**From:** David Meagher [REDACTED]  
**Sent:** 13 May 2021 16:37  
**To:** Finlay Gardner <[Finlay.Gardner@arun.gov.uk](mailto:Finlay.Gardner@arun.gov.uk)>  
**Subject:** Objection to BR/93/21/PL 22 Neville Road

OBJECTION - BR/93/21/PL - development at 22 Neville Road PO22 8BN

OBJECTION - BR/93/21/PL - 22 Neville Road PO22 8BN

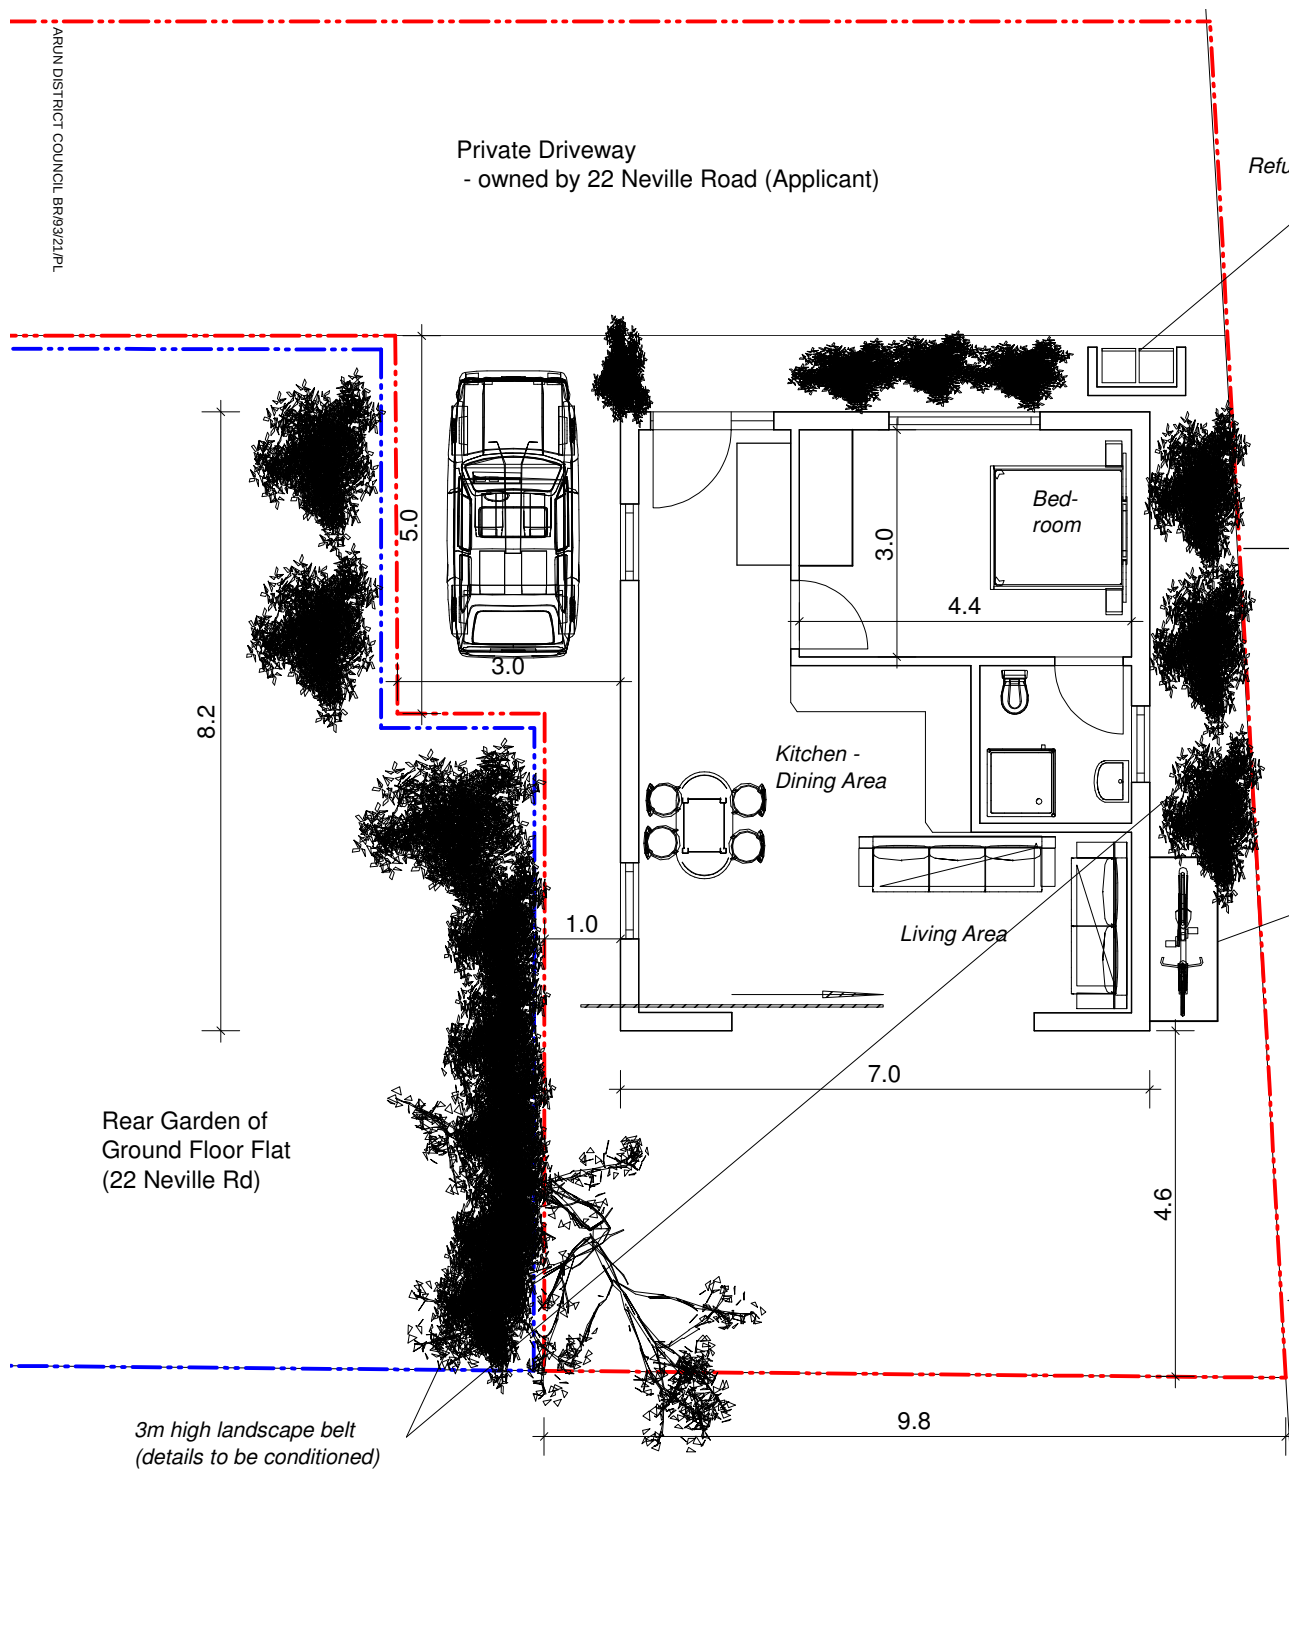
All development proposals should make efficient use of the land but reflect the characteristics of the site and local area in their layout. The surrounding properties are pitched roof two storey properties, with rear garden space. This proposal is a small flat-roofed single story and removes garden space contrary to the character of the area. It does not reflect the existing street frontage and massing of existing residential houses, character, and finish. It does not mitigate the loss of biodiversity and leaves questions and concerns for the health and well-being of potential residents in the long term (P151).

There is no scope for a high standard of architectural use of materials and craftsmanship. This is a brick box with picture windows on one side and all other singular windows in the three sides in obscured glass.

The form shape and design are of a sub-standard quality which is presented by a flat-roofed brick block construction punctuated by windows of obscured glass and patio windows with a garden depth of 4.6 metres. The proposal contravenes Arun's Design Guide which specifically mentions that developers should avoid building on back gardens. In this case the proposal does not measure up to the recommended 10.5 metres.

SPG states that gardens should have a minimum depth of 10.5 metres of space. The applicants proposal subverts this guidance by the plan to build on the two gardens used by the tenants at 22 Neville Road, who have no opportunity of growing their own produce, providing a minimal amount of usable space for the proposed dwelling. The proposed dwelling does not have a proportionate amount of rear garden.
